Ribble Valley Borough Council
Housing & Development Control

Application no: **3/2020/0008**

Address: **The Judge Walmsley Hotel Whalley Road Billington BB7 9TP**

Proposal: **Change of use of public house (use class A4) to children's day nursery (use class D1)**

PROPOSED PLANS

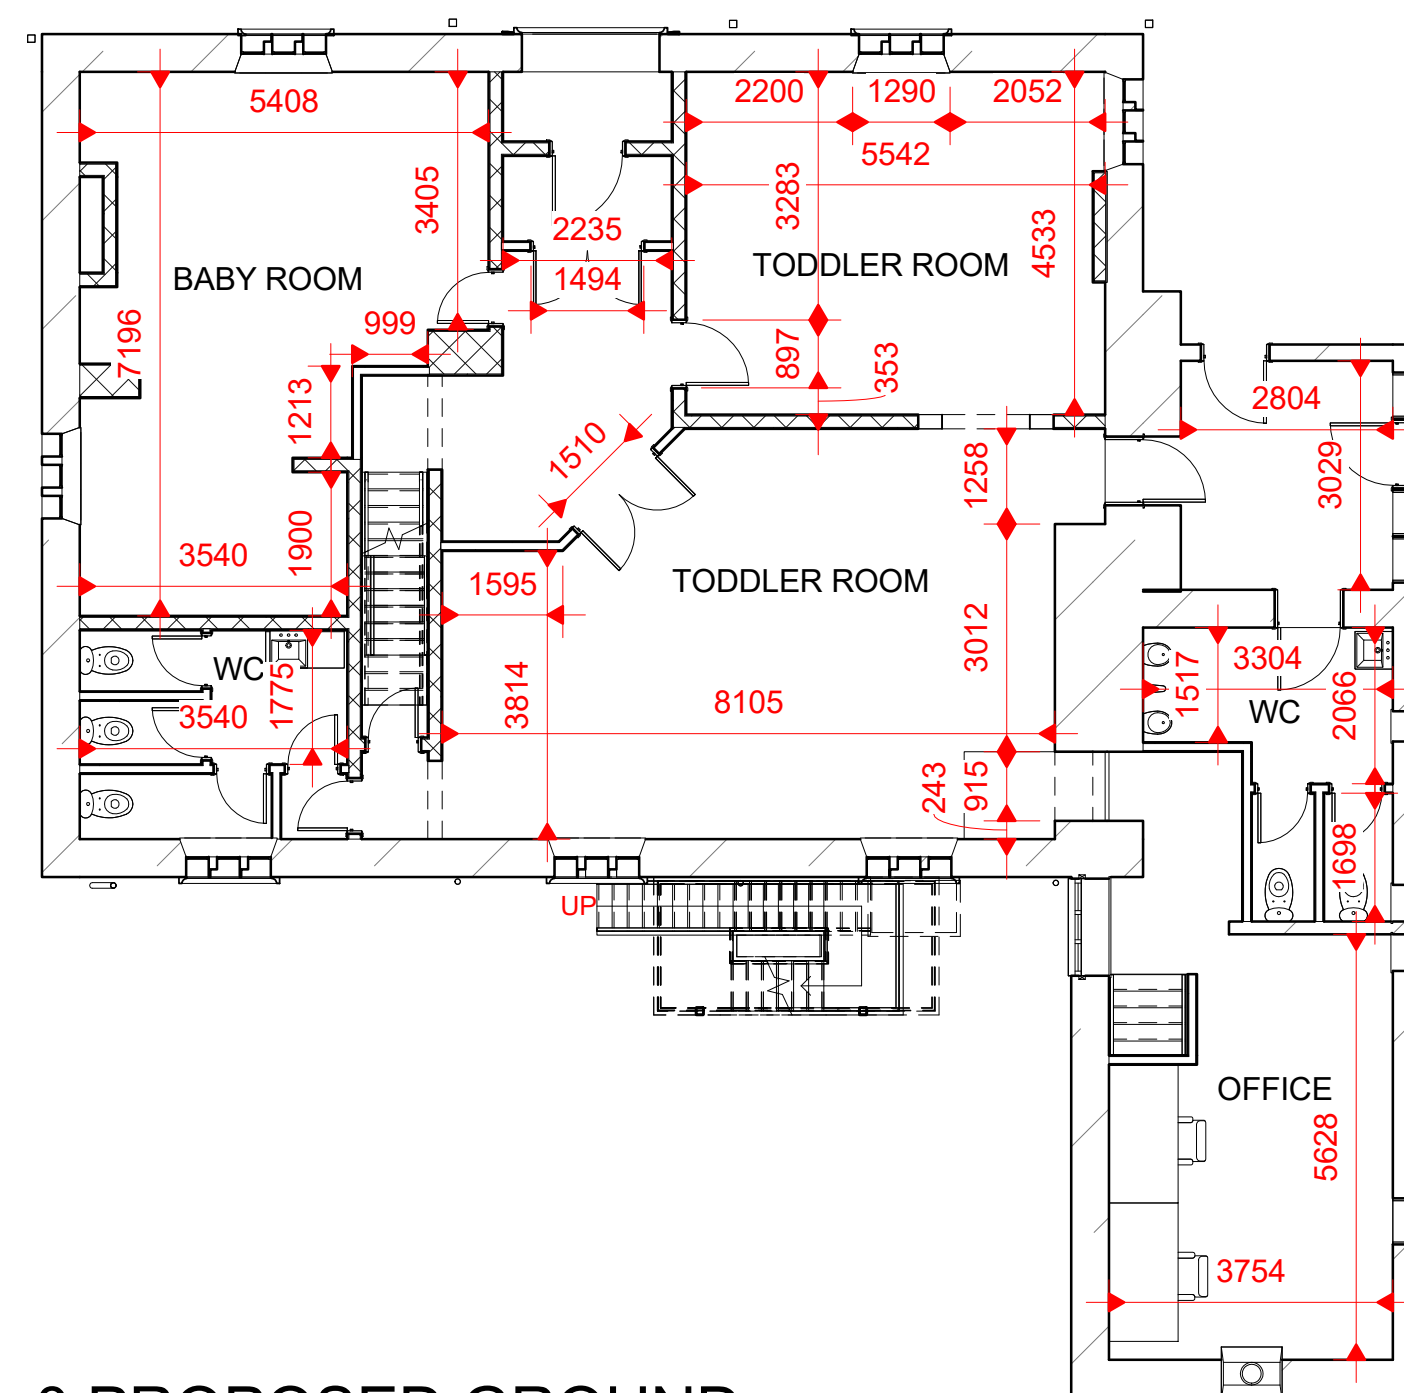
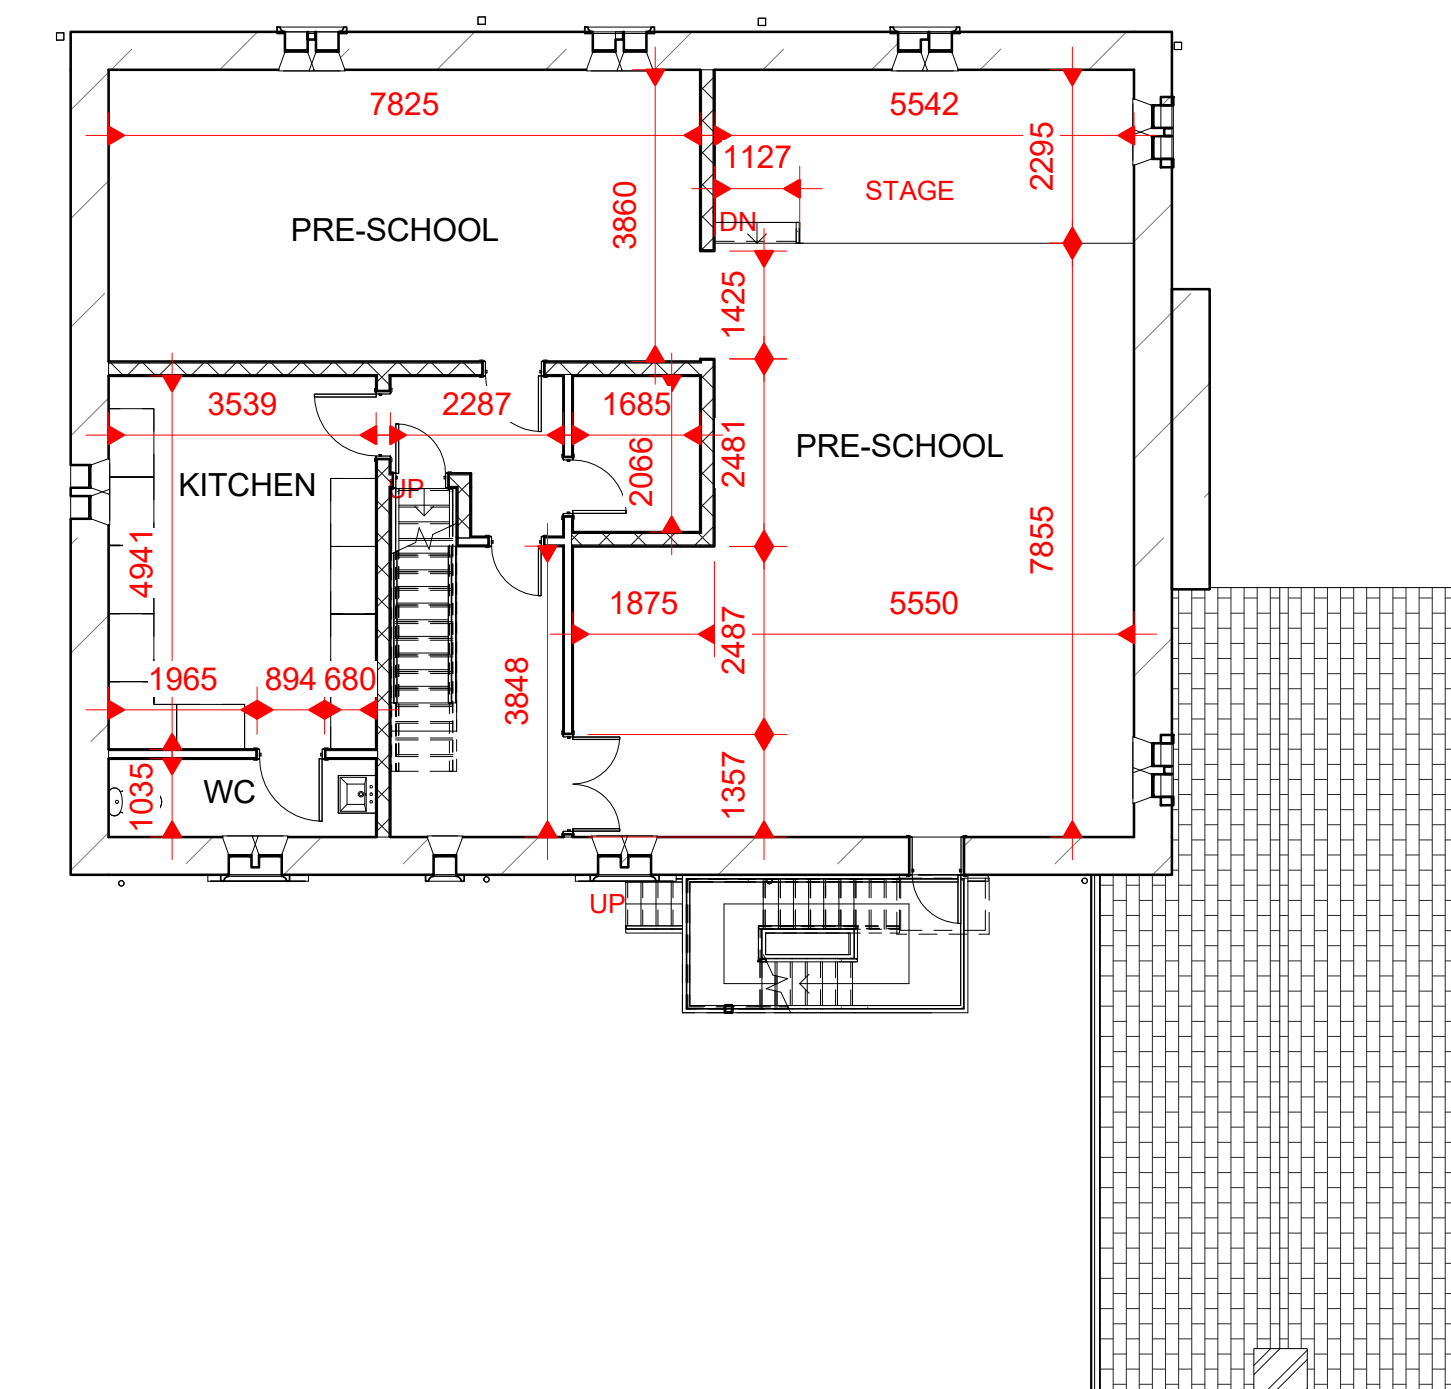
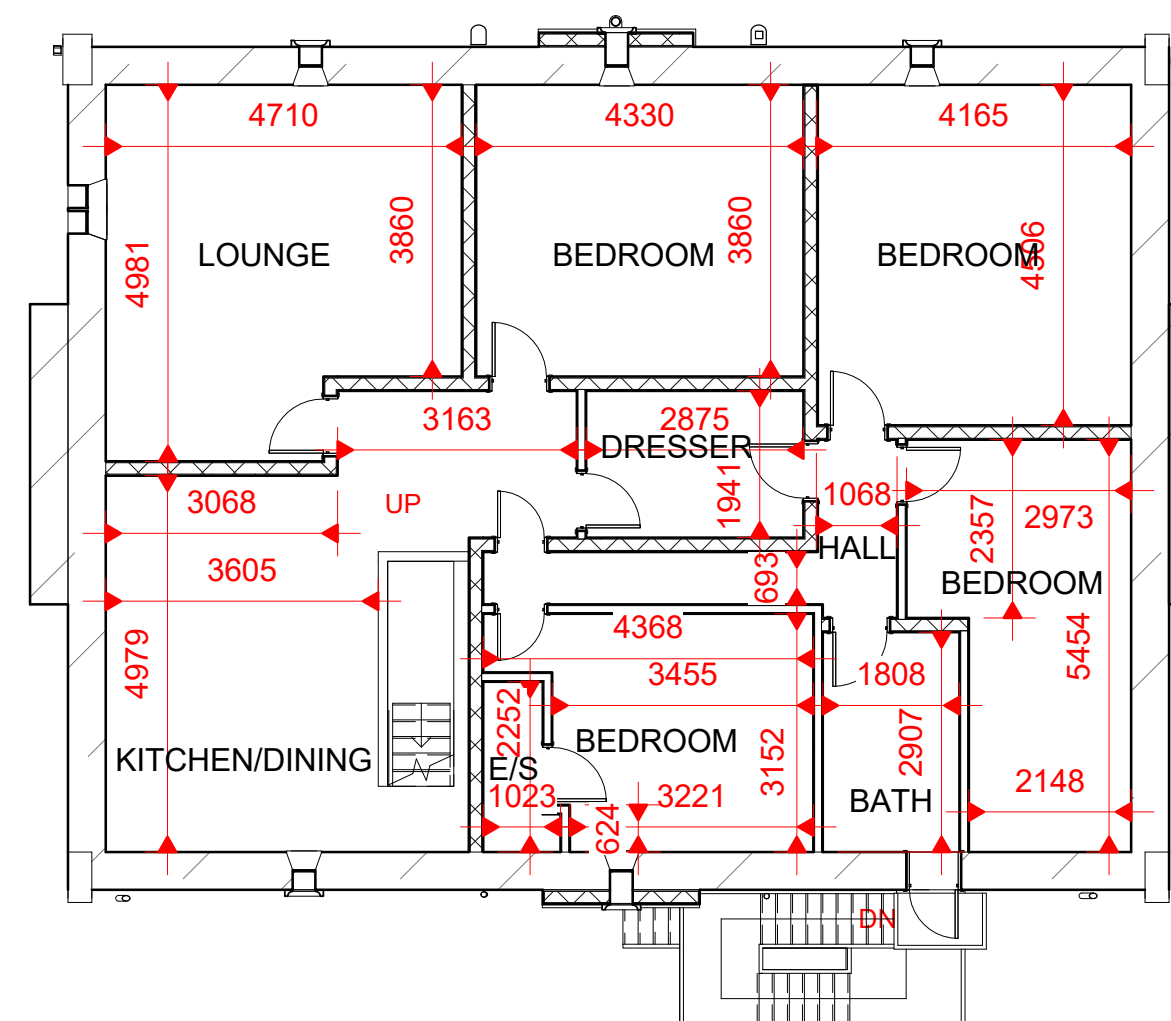
The entrance of the nursery would need to be formed with a ramped access as opposed to the current stepped access to provide an ease of inclusive mobility. Following guidance contained within the Department of Transport's publication, Inclusive Mobility. Taking into consideration the gradients of the ramp for those with limited mobility.

# PROPOSED SITE PLAN

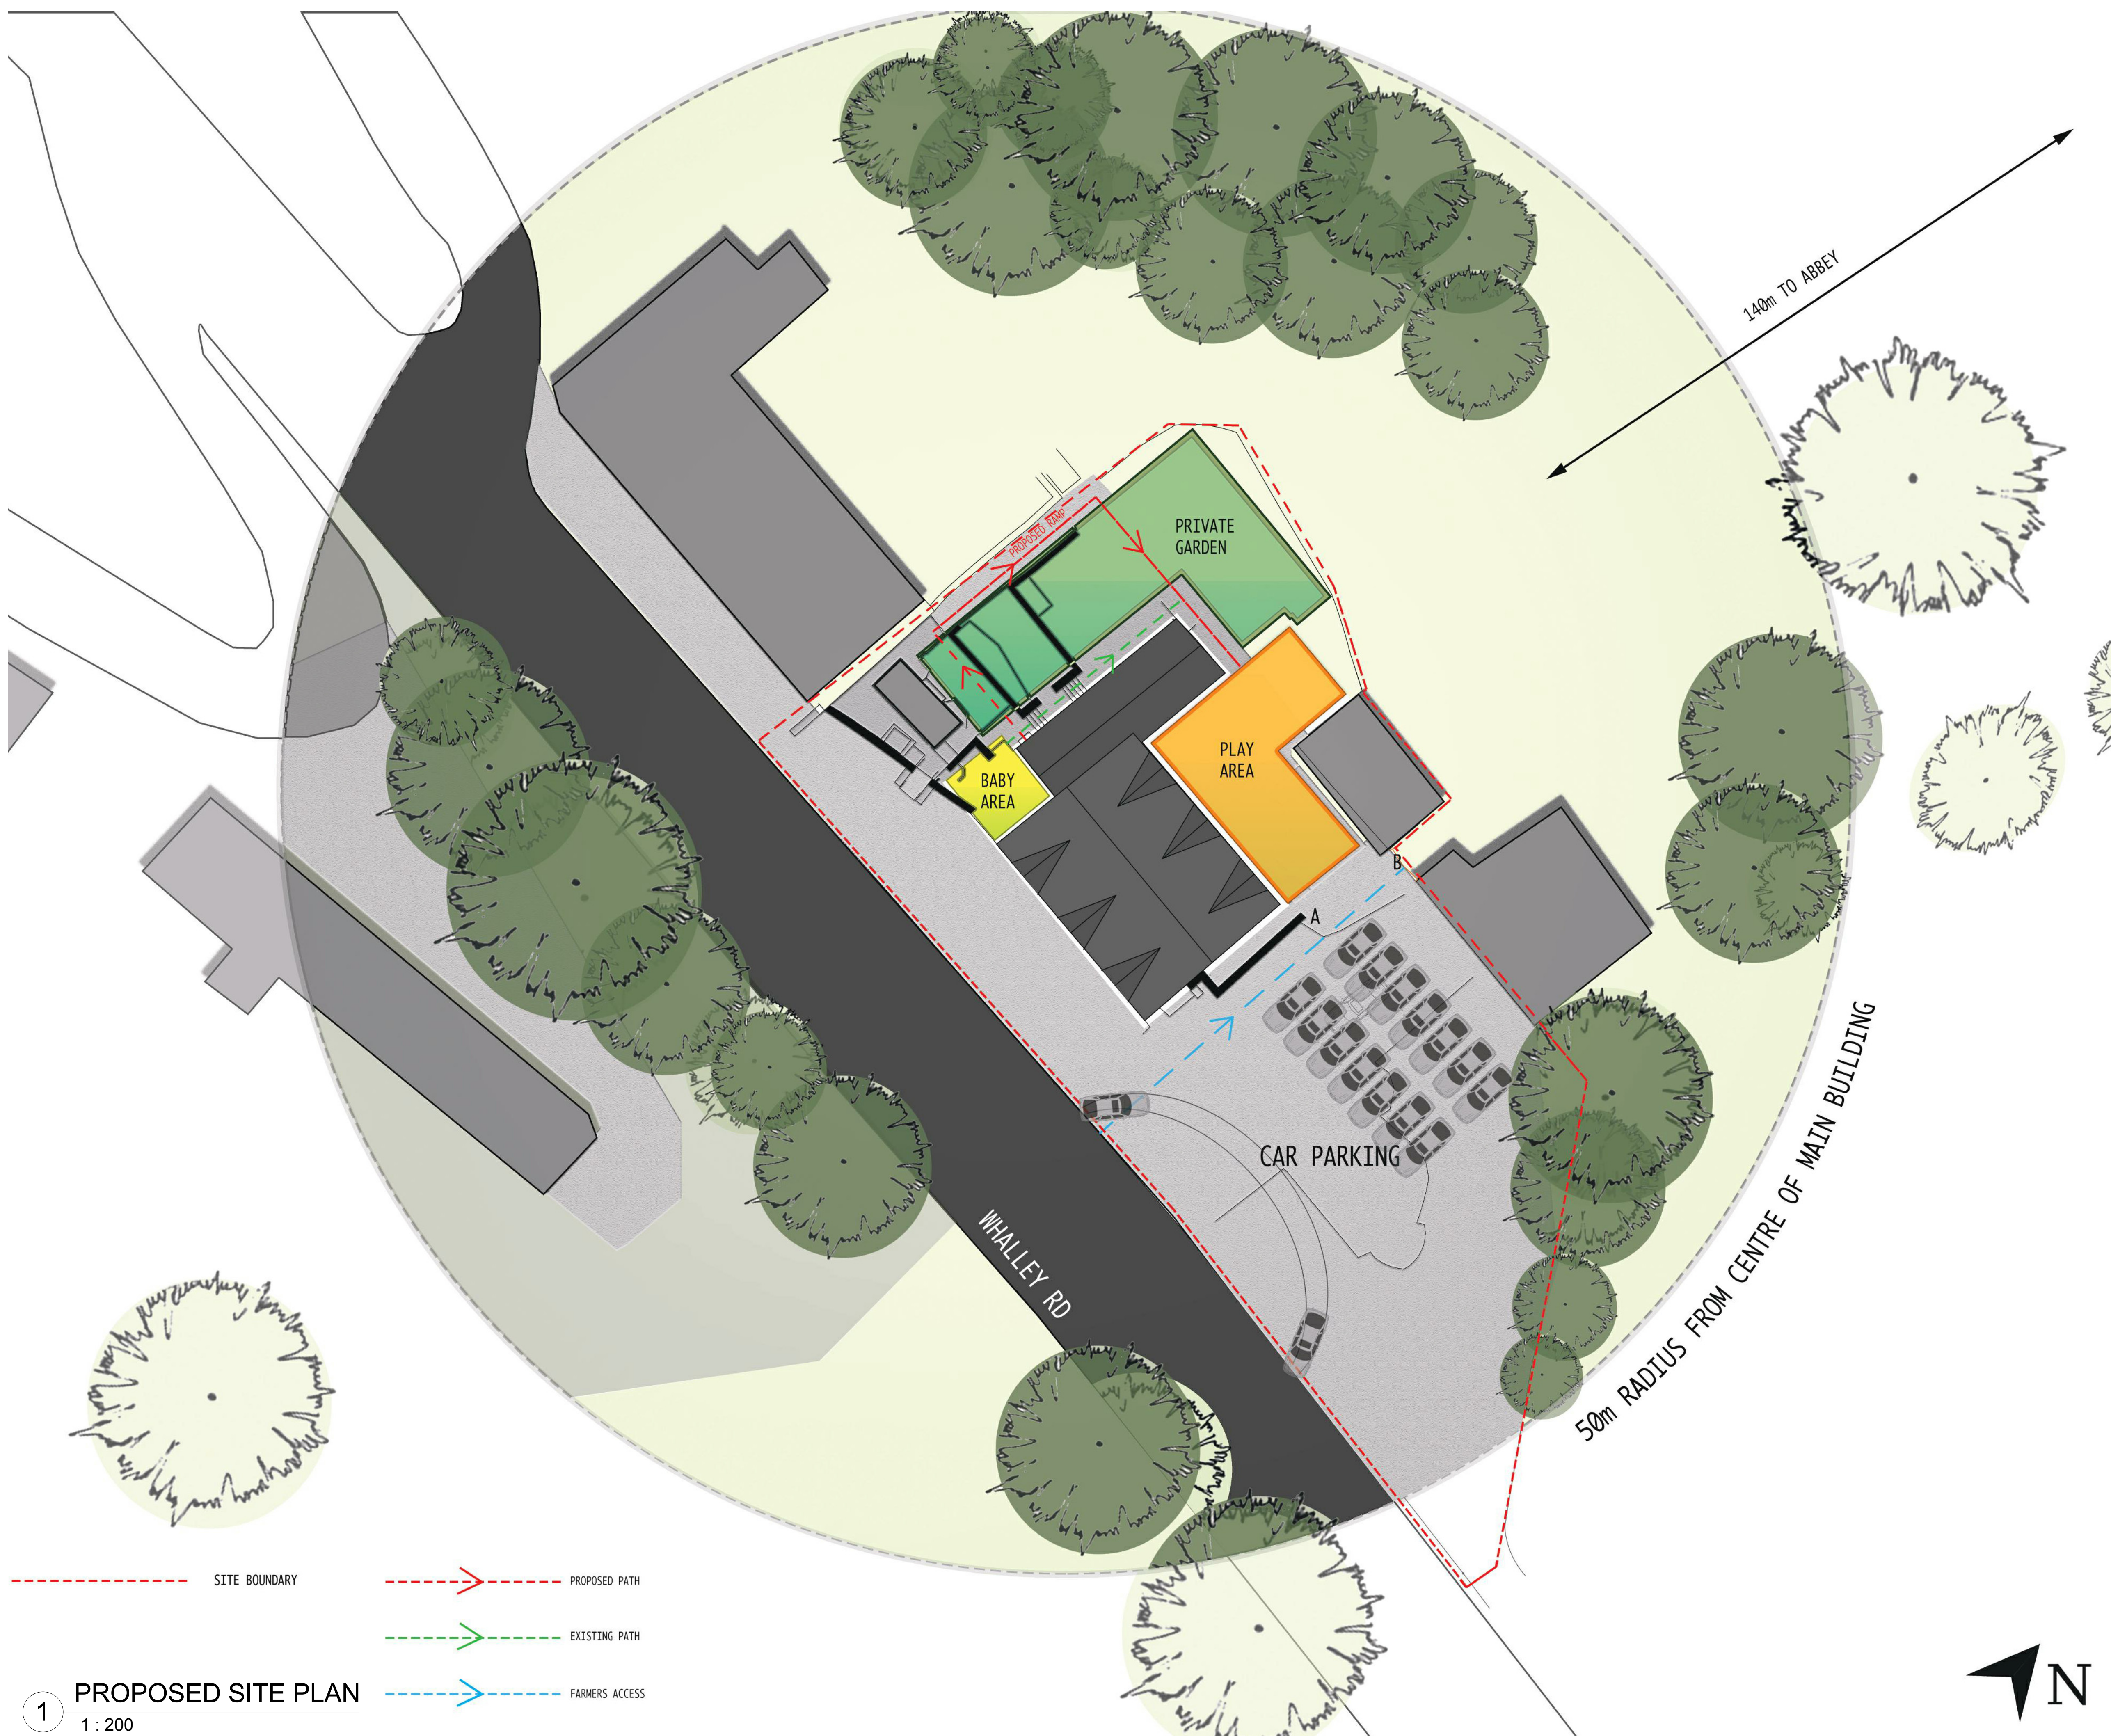
There is three access points fronting the application site whereas the applicant proposes to utilise two of the existing access points fronting the car park in an in/out configuration.

Visibility splays to the access points are generally good however the proposed in/out configuration will need to defined by the placement of signage to both the access point and exit point in order to distinguish vehicular access / exit to and from the application site.

The third access point, the most South Westerly access point into the application site will need to be reinstated up to full footway construction which would formalise the closure of the access point, providing safety to pedestrians whilst accessing and leaving the entrance of the nursery.

The submitted application form states that 15 parking spaces are required for the proposal which would comply with the required parking standards however the introduction of one additional mobility parking space would be required to meet the required inclusive mobility parking provision.

Furthermore, the proposed parking arrangements are considered unsatisfactory and to discourage on-street parking the applicant would need to delineate the proposed parking spaces in a perimeter parking configuration in order to provide an acceptable parking layout.

The applicant would also need to demonstrate where they intend to store refuse and also provide details of a refuse collection point which is anticipated to be collected commercially by a contractor who shall be organised by the applicant.

I would ask that the plans are revised detailing the above.
